ENG-CDR21010-R3-CDs-Barbarick-Ultimate.pdf Markup Summary

VOLLMER ROAD (NORTH)
ROADWAY PLAN & PROFILE

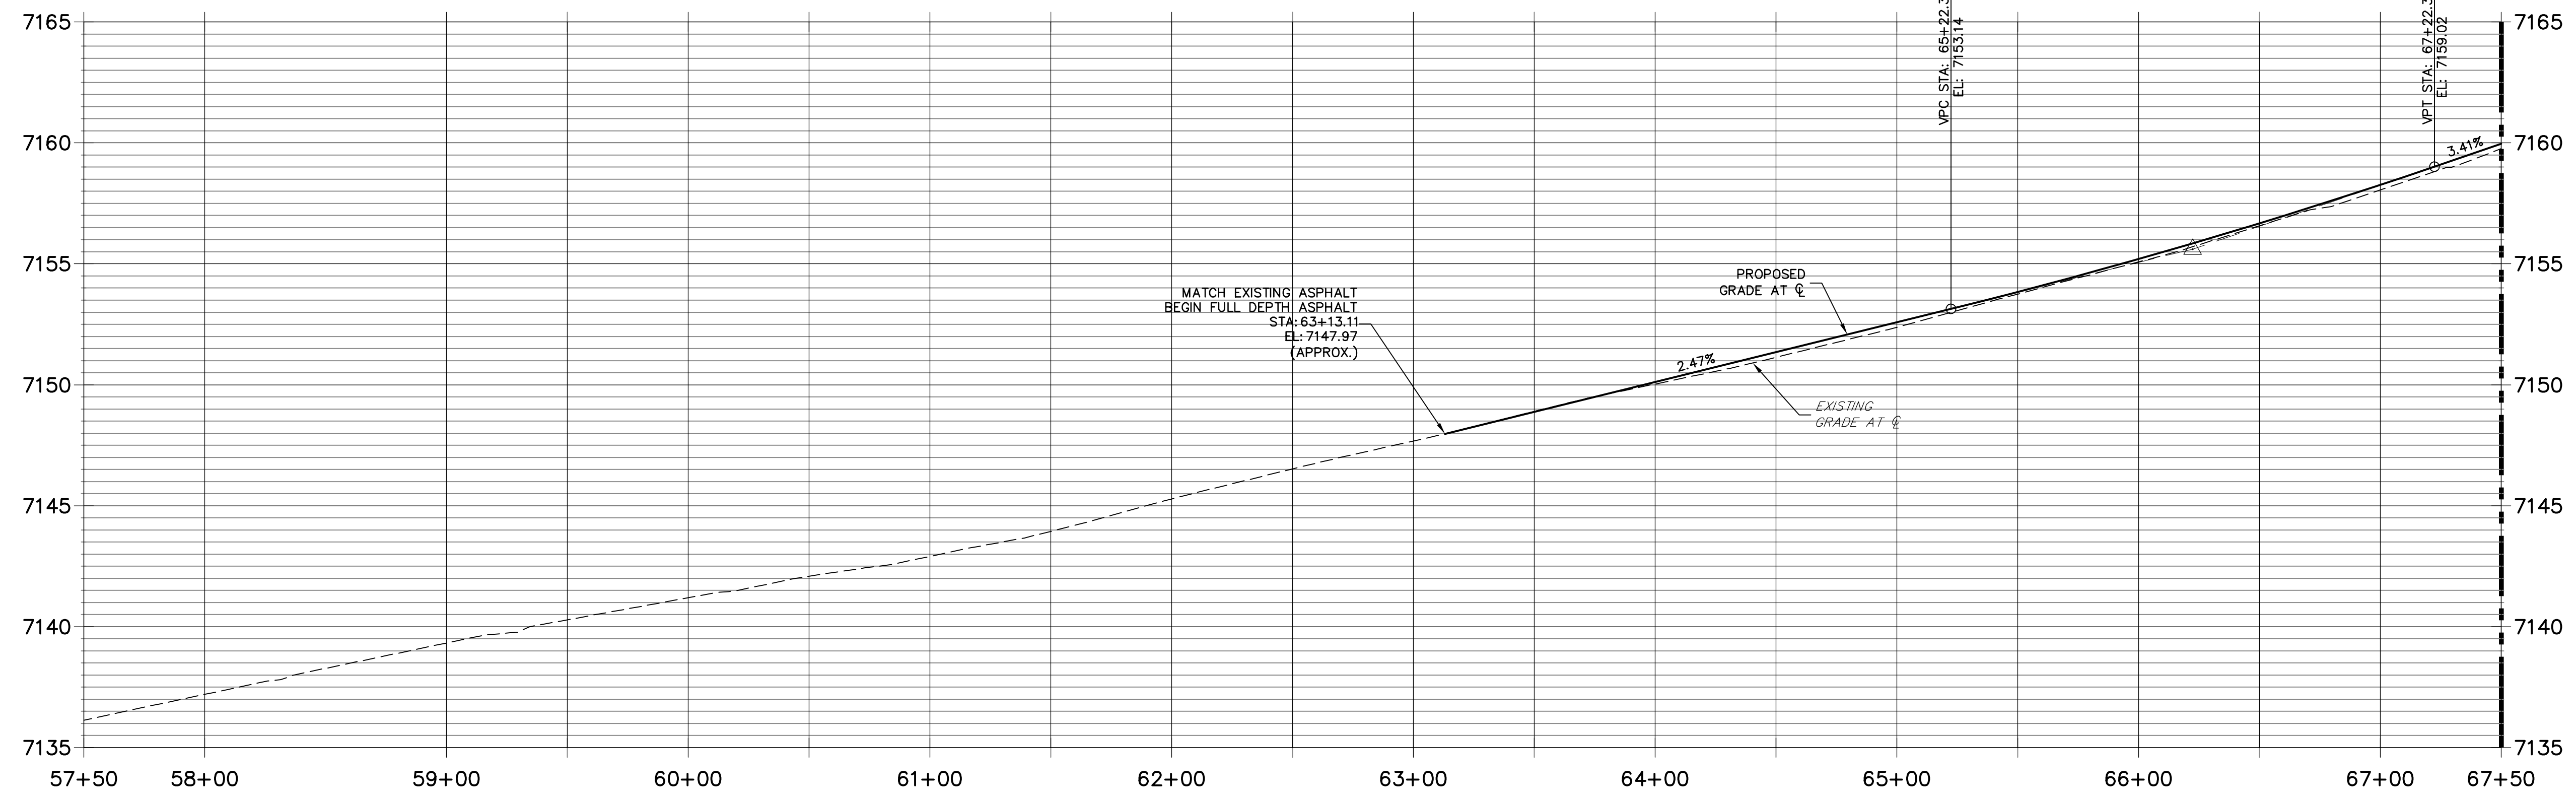
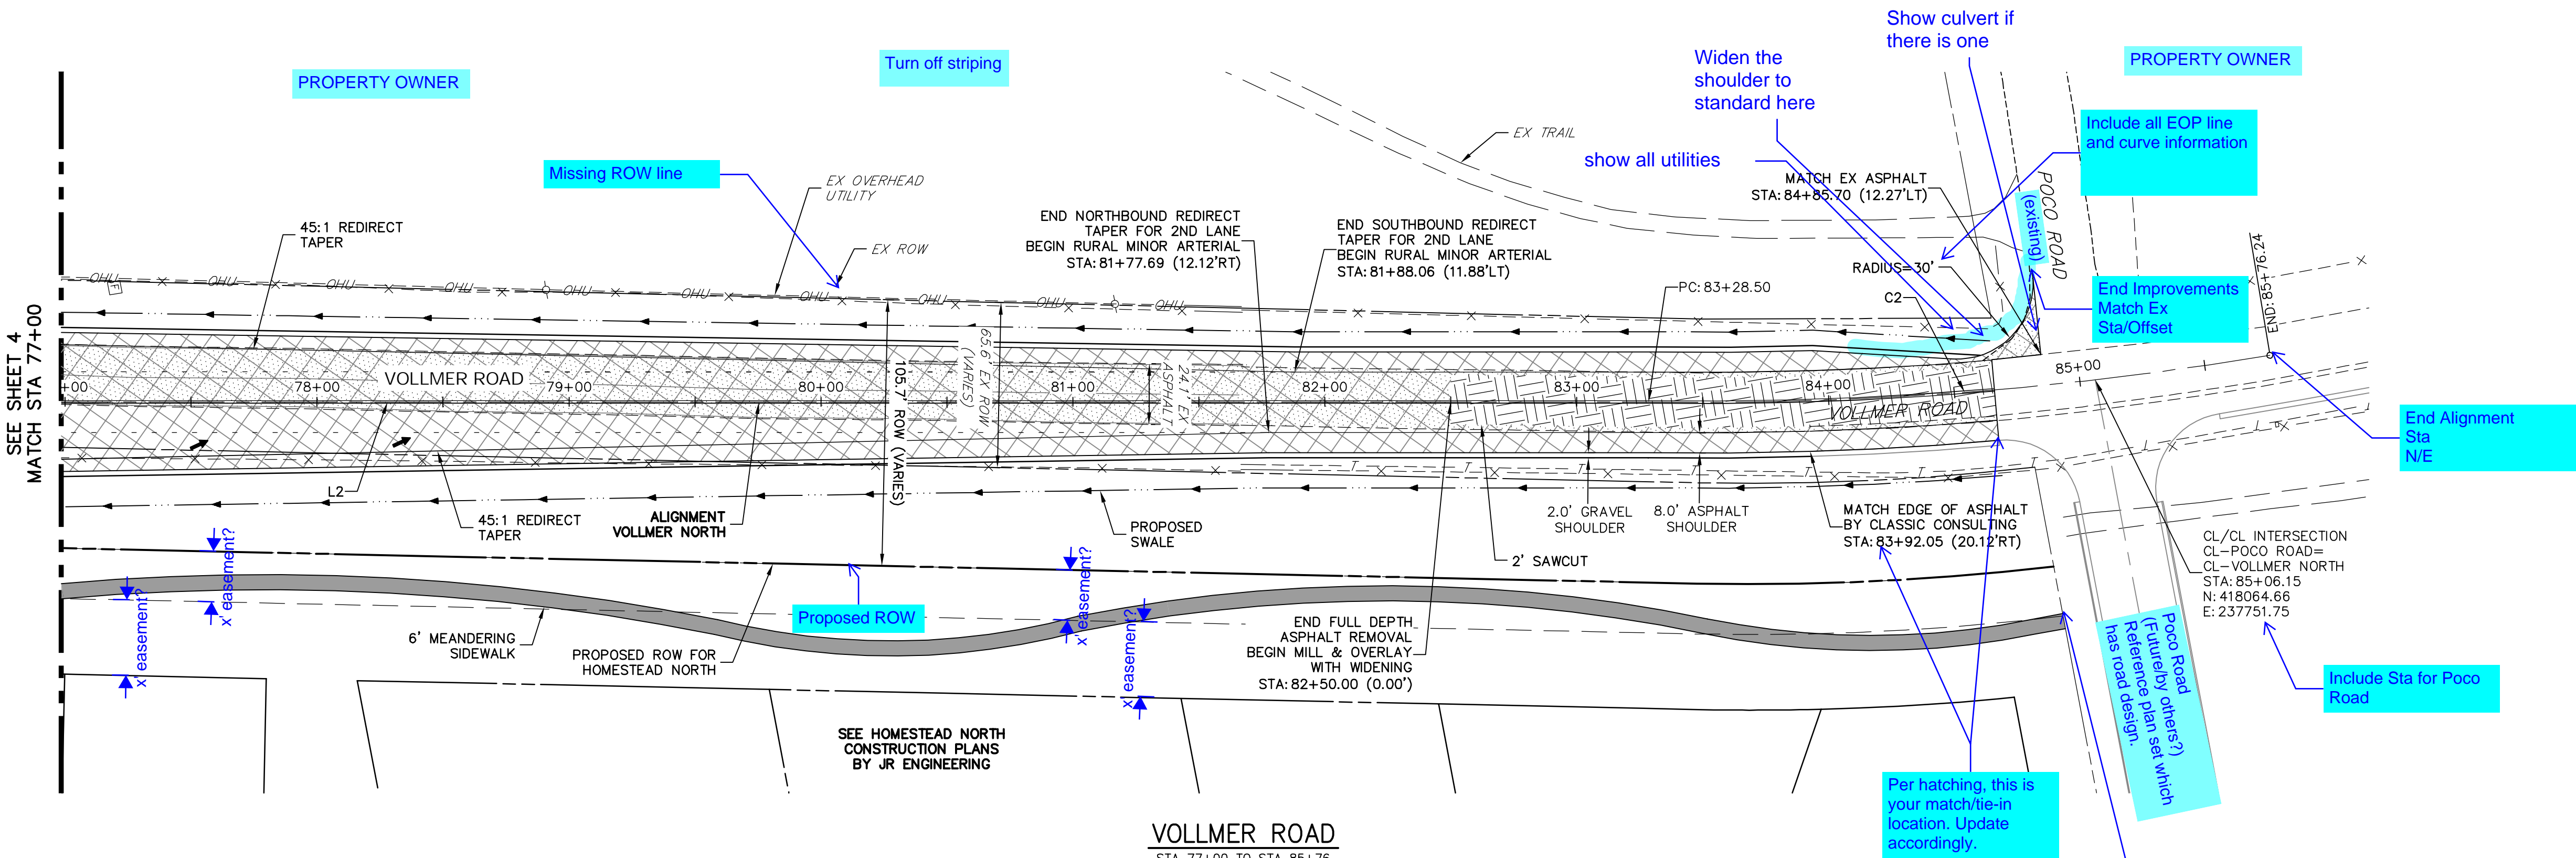
Label and show plowable median nose

VOLLMER ROAD (NORTH)
 ROADWAY PLAN & PROFILE

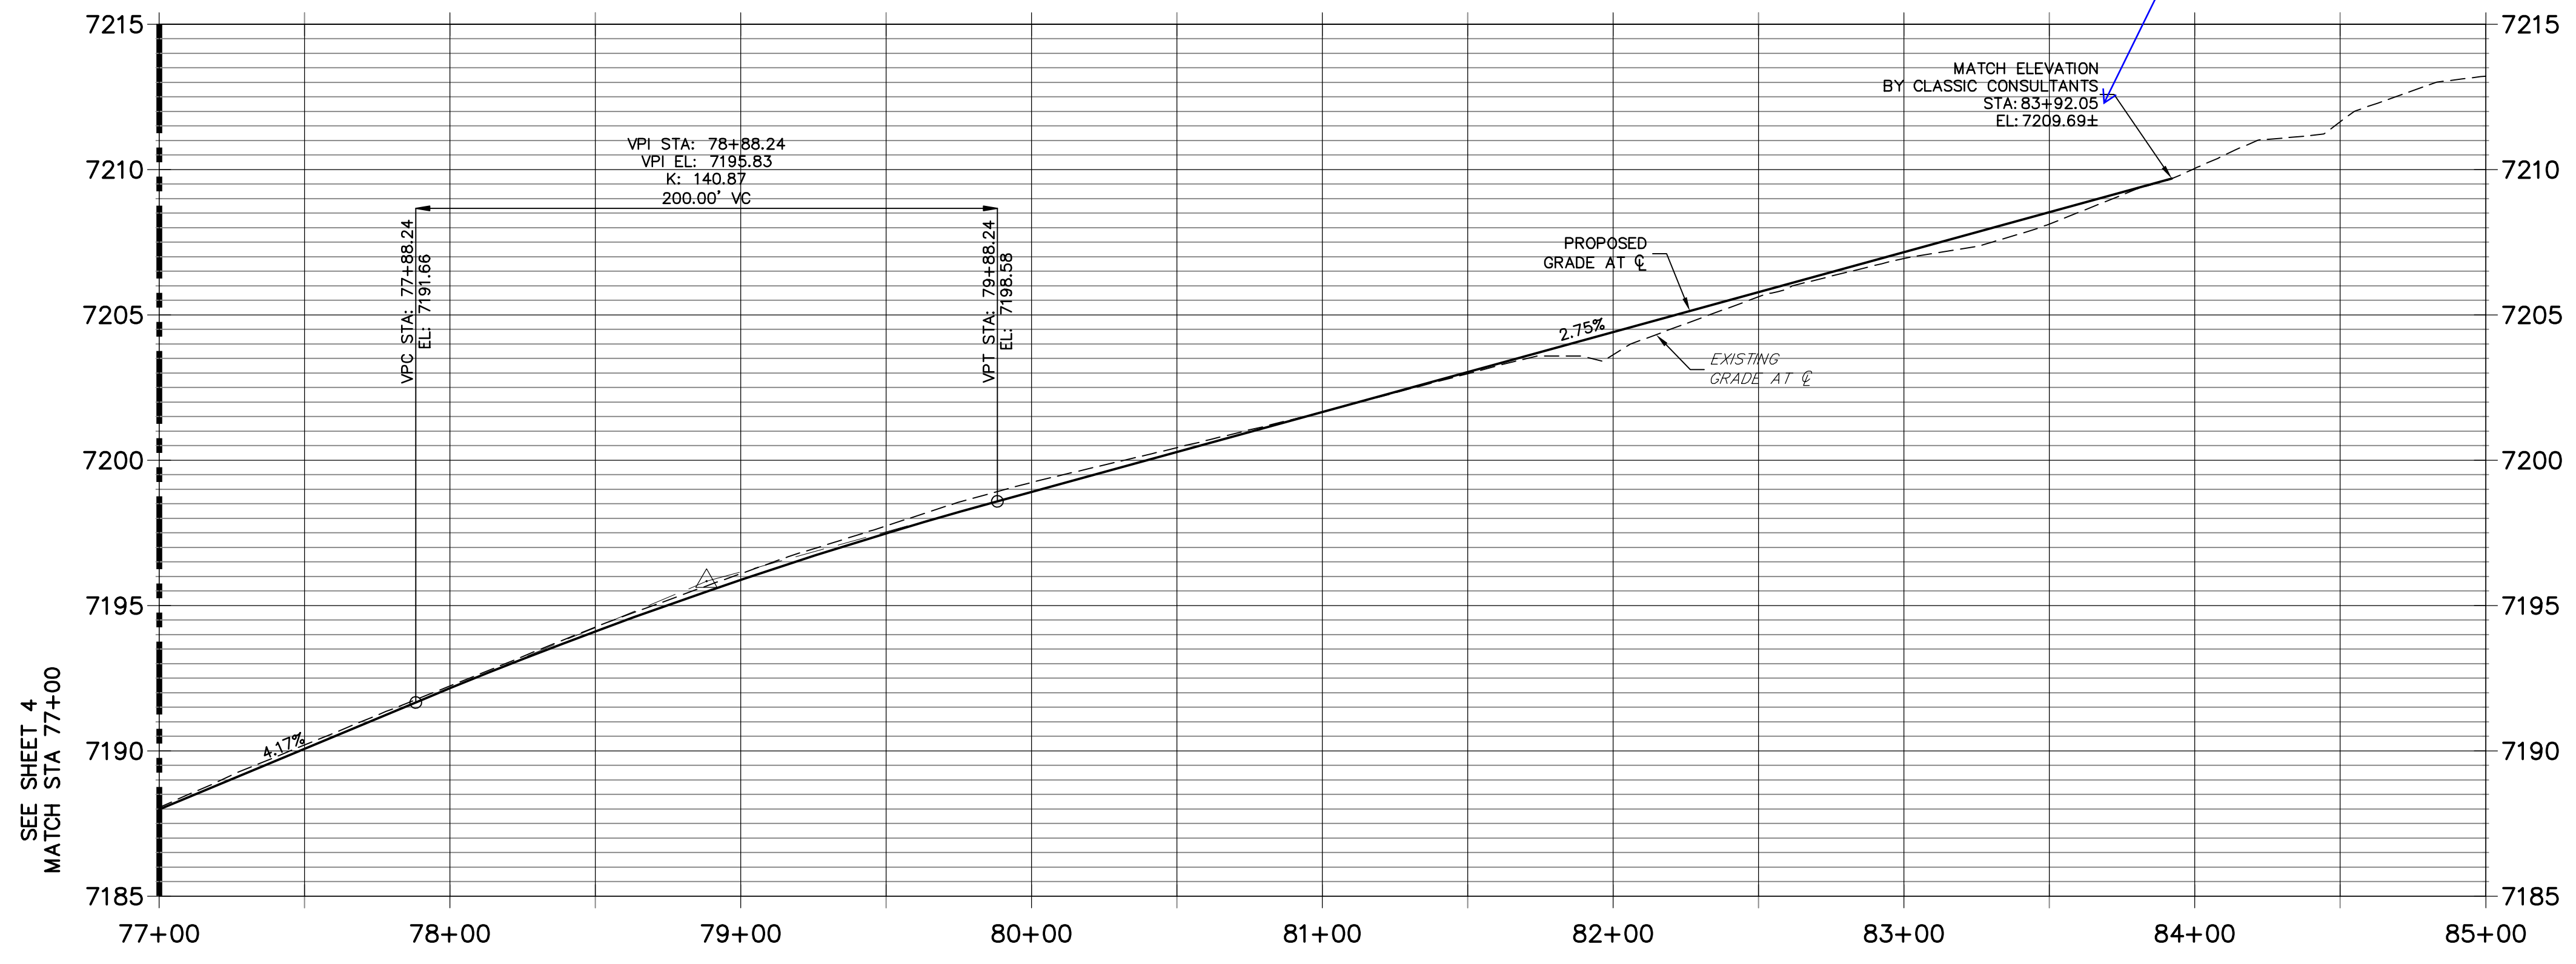
Add plowable median nose

VOLLMER ROAD (NORTH)
 SIGNAGE & STRIPING

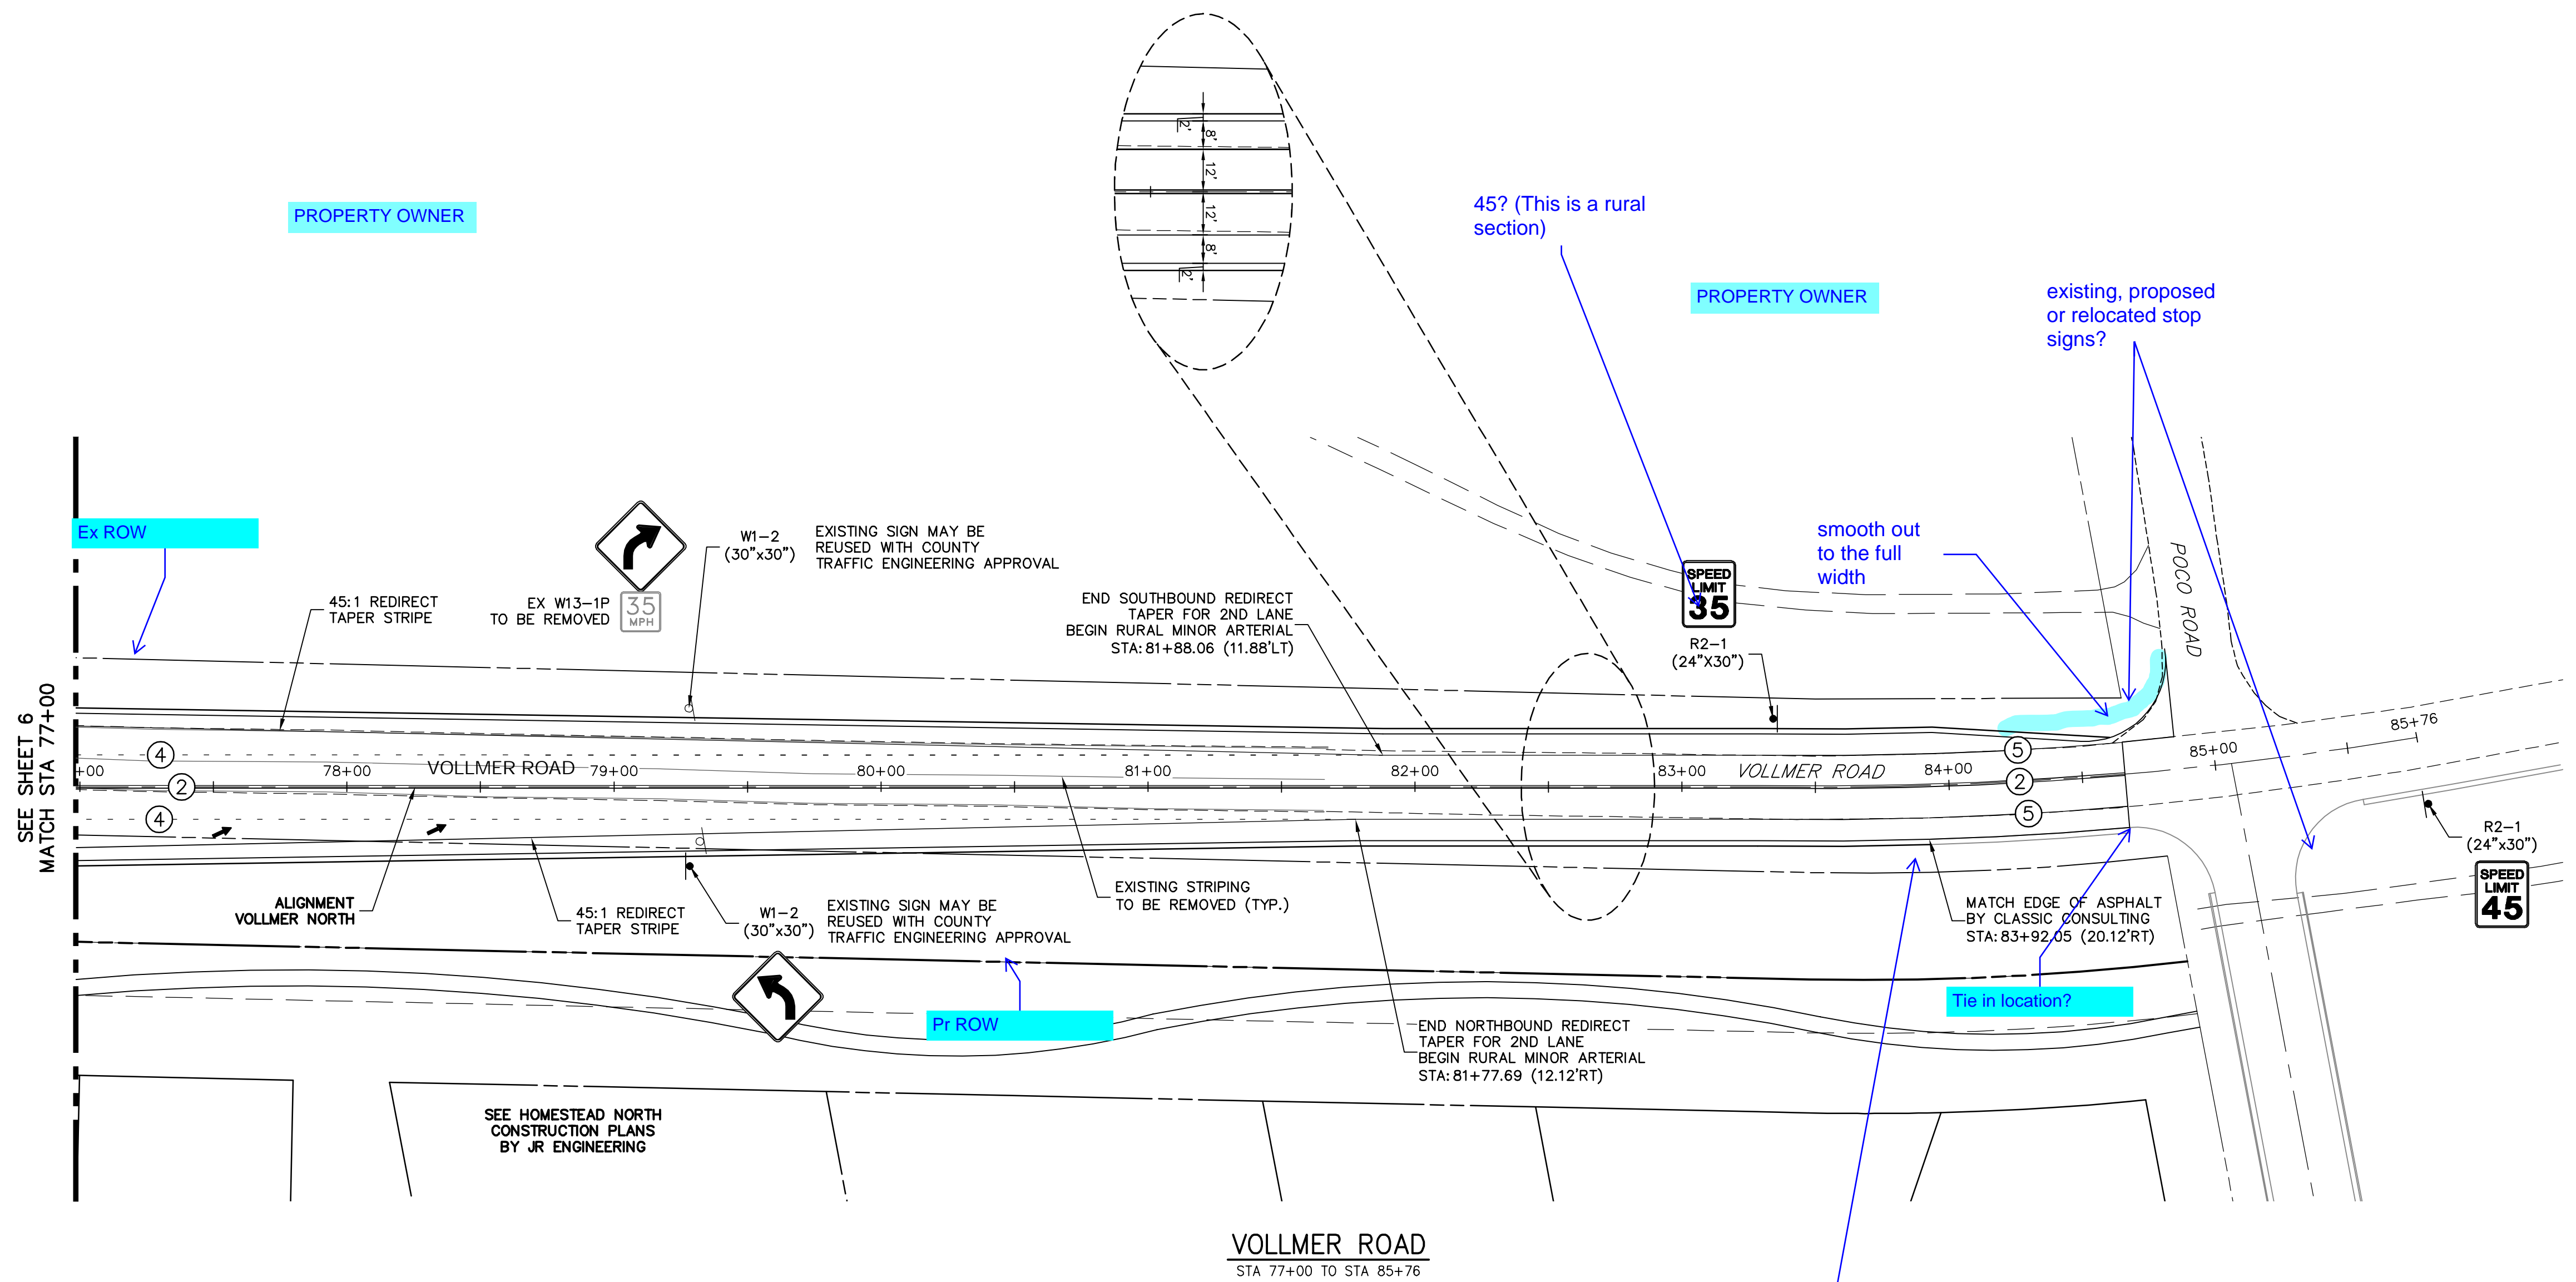
Need profile for culvert

Label where c&g ends

Utility box need relocated?

Note should point to utility poles.

Relocate utility box? This is not an overhead structure

CL-CL intersection note

Show culvert profile

Relocate driveway to Glider Loop
